Appeal Decision

Appeal Ref: APP/R5510/D/22/3300420

119 Cleave Avenue, Hayes UB3 4HD

- The appeal is made under section 78 of the Town and Country Planning Act 1990 against a refusal to grant planning permission.
 - The appeal is made by Mr Shamsher Singh against the decision of the Council of the London Borough of Hillingdon.
 - The application Ref 74798/APP/2022/421, dated 10 February 2022, was refused by notice dated 7 April 2022.
 - The development proposed is part first floor rear extension.
-

CLIENT	Shamsher Singh
PROJECT	119 Cleave Avenue Hayes - Middlesex UB3 4HD
DRAWING TITLE	Proposed Part Double Storey Rear Extension Proposed Floor Layouts Sheet 3

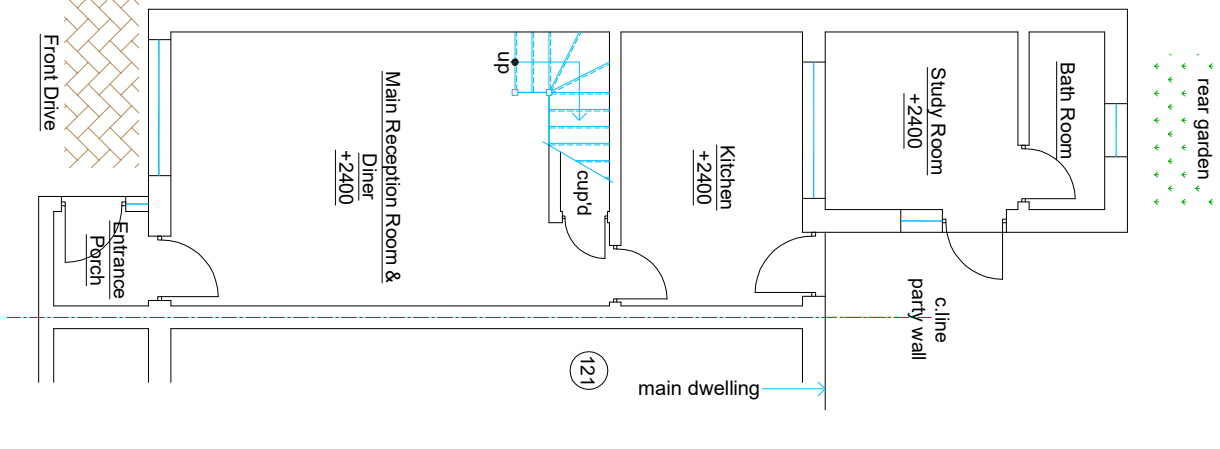
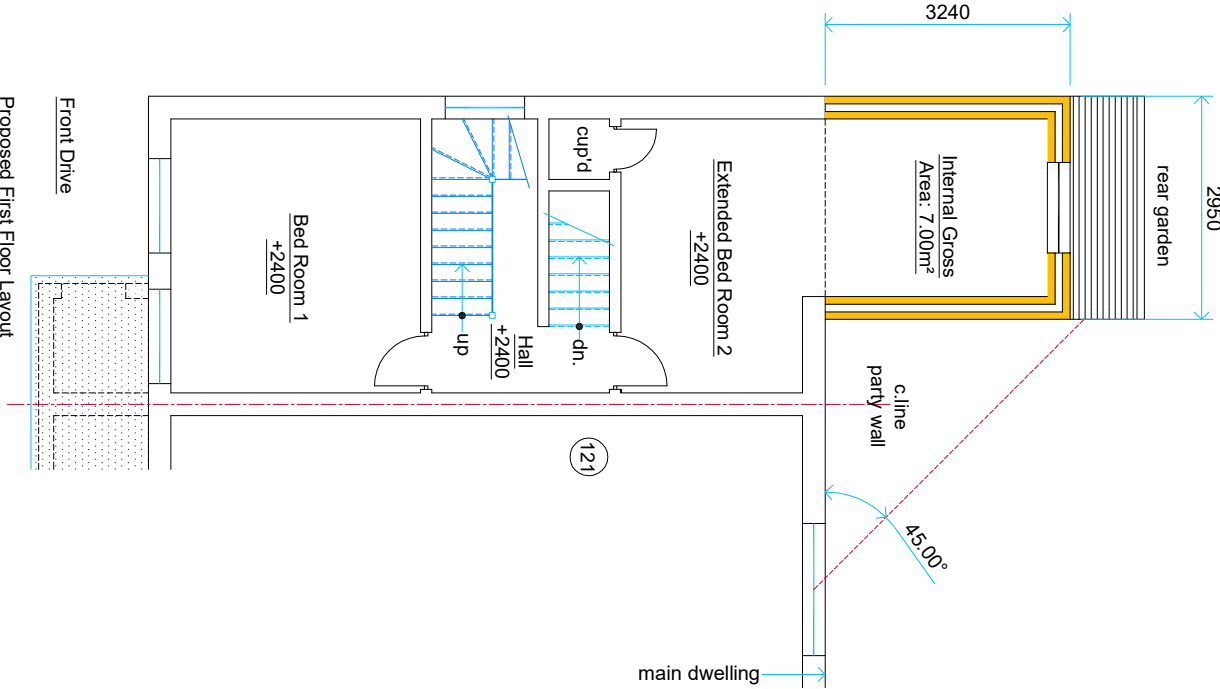
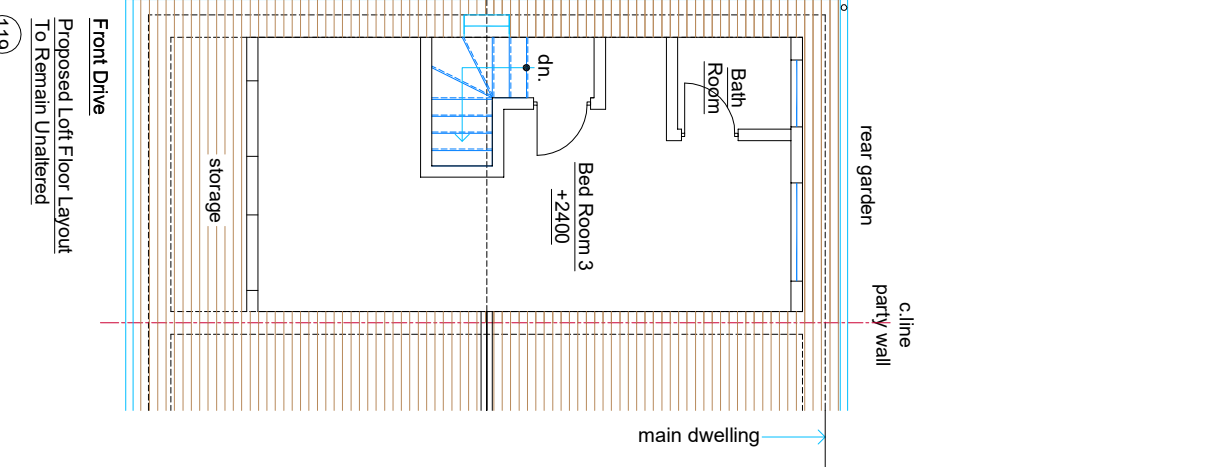
4. The extension would be set in from the boundary with the adjoining neighbour at 121 Cleave Avenue, but it would still cover a fairly large proportion of the width of the rear of the appeal dwelling, and would add significant bulk and mass to the upper part of the building. In combination with the existing ground-floor extension and large rear box dormer, the extension would be a disproportionate addition relative to the host property and site, and I find that it would dominate and overwhelm the proportions of the dwelling to the detriment of its character. The visual impact of the scale of development on the appeal site would be further exacerbated by the stark contrast with the much more modest scale of other buildings nearby where I saw very few examples of extensions above ground floor level.

8. The submitted plans indicate that the development would accord with the requirement within LPP2 Policy DMHD 1 that two storey extensions should not extend into an area provided by a 45-degree line of sight drawn from the centre of the nearest ground or first floor habitable room window of an adjacent property. However, the supporting text to the policy outlines that while the '45-degree rule' provides a general guide to what is normally considered acceptable, there may be occasions when an extension is considered unacceptable even if it appears acceptable on paper.

DRAWING TITLE
Proposed Part Double Storey
Rear Extension
Proposed Elevations
Sheet 4

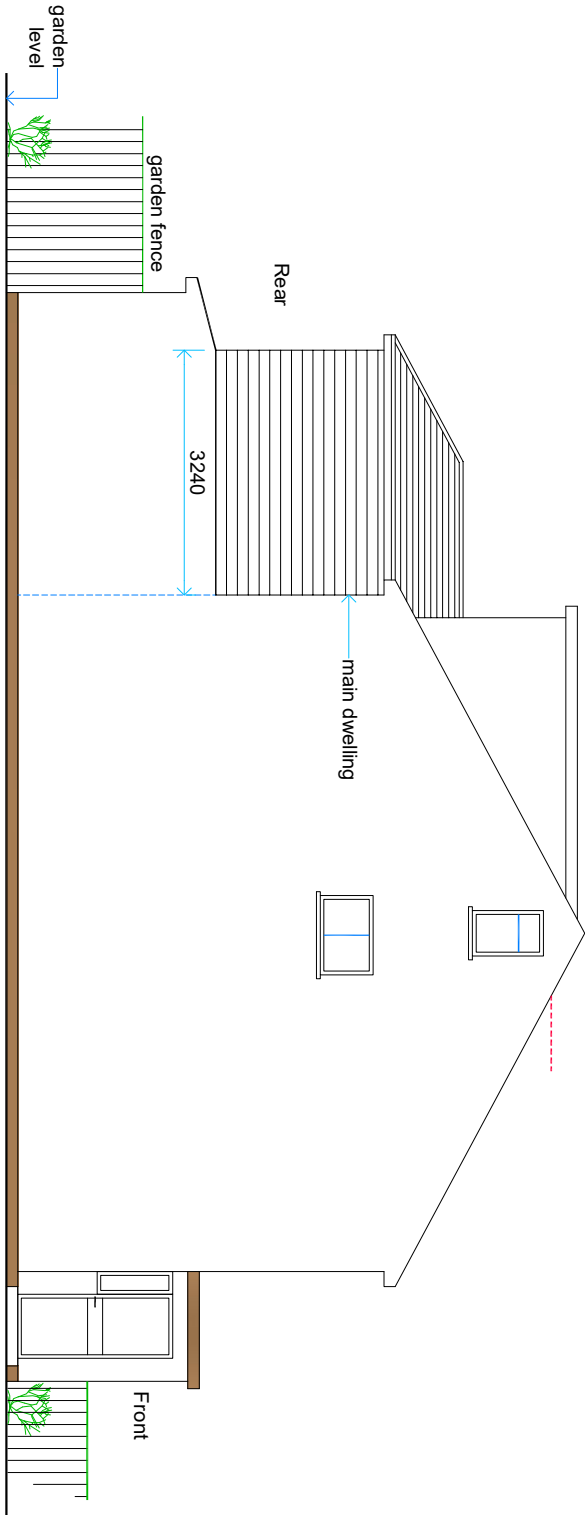
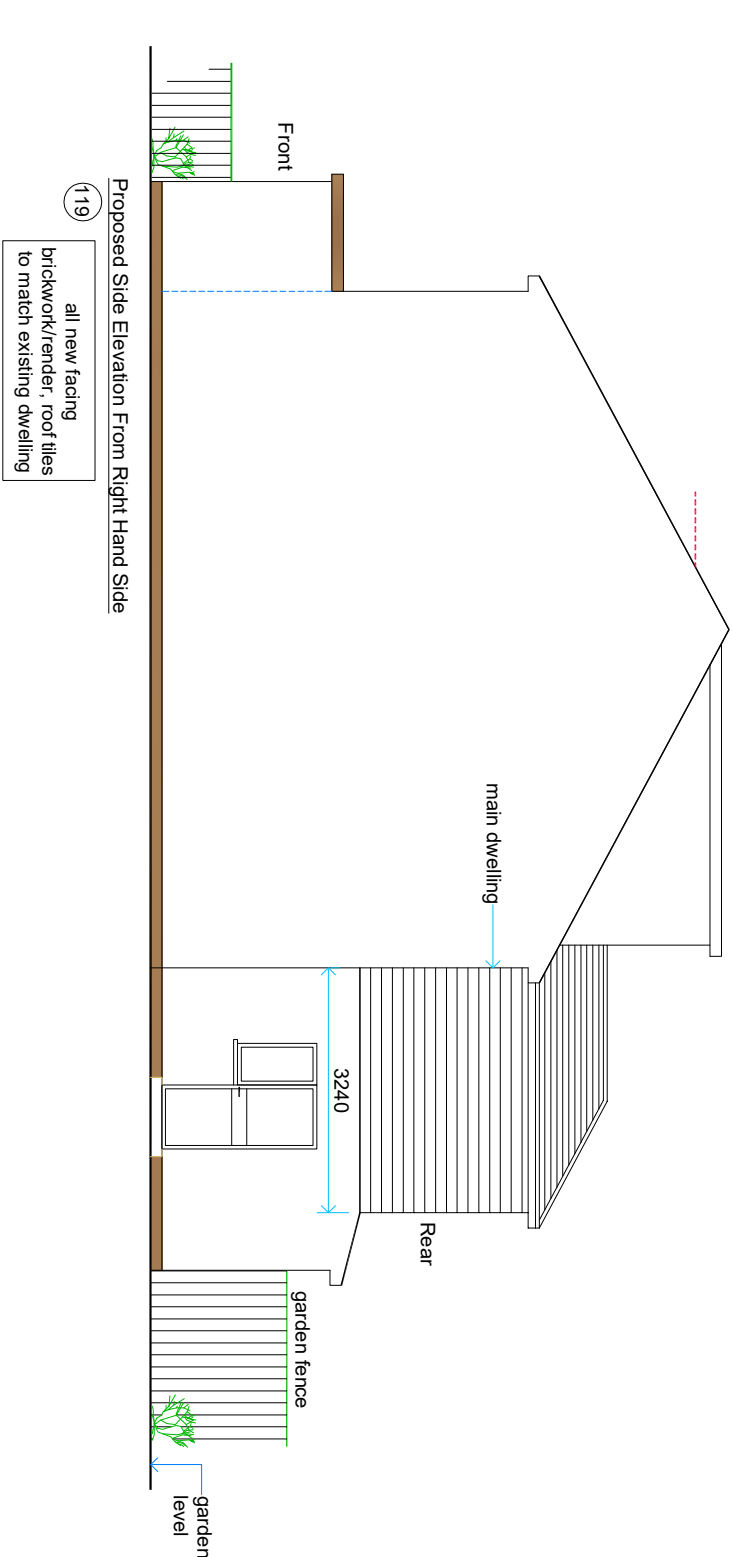
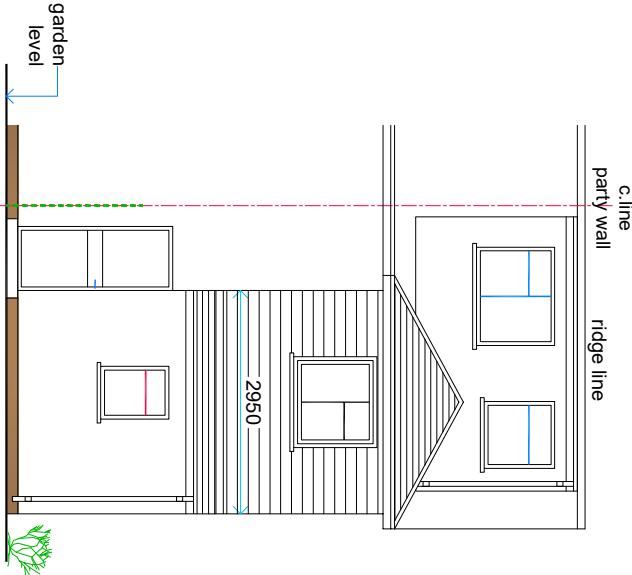
should be of a similar pitch and materials to that of the original roof and subordinate to it in design. The hipped roof of the extension would be out of keeping with the pitched roof form with gable ends that is typical within the area, and would also contrast with the flat roof to the dormer, resulting in an awkward mix of roof forms to the upper part of the dwelling which I consider would be discordant.

6. At my visit, I saw that the existing rear extension and dormer are appreciable in views from Cleave Avenue given an access to the side of the dwelling which provides for spacing to the neighbour at 117 Cleave Avenue. The proposed extension would be similarly visible, and while I acknowledge that the full scale of the development would not be apparent from the street scene, it would nevertheless stand out as an incongruous feature which would be unsympathetic to the character and proportions of the host building. It would also be plainly visible from neighbouring gardens and windows, as well as from the row of garages to the rear of the site.

9. In this case, the development would be set in from the boundary with No 121, but the separation would not be large, and it would project along a fairly significant proportion of the depth of the boundary. It would be much taller than the existing rear extension, and I consider given the modest overall size of the gardens here that the depth and two-storey height of the development would present a highly dominant and overbearing feature when seen at such close range from No 121. The height and additional bulk at first floor level would also give rise to an unwelcome degree of enclosure, and I find that there would be a notable loss of outlook which would harm neighbouring occupiers' quality of life.

10. That the extension would not breach the '45-degree rule' suggests to me that daylight to No 121 may not be unacceptably reduced. Given however the tight relationship of the extension with this neighbour and the orientation of the site, I am concerned that the greater height of development on the appeal site would be likely to give rise to some increased overshadowing of windows and space to its rear. I have not been provided with substantive evidence to
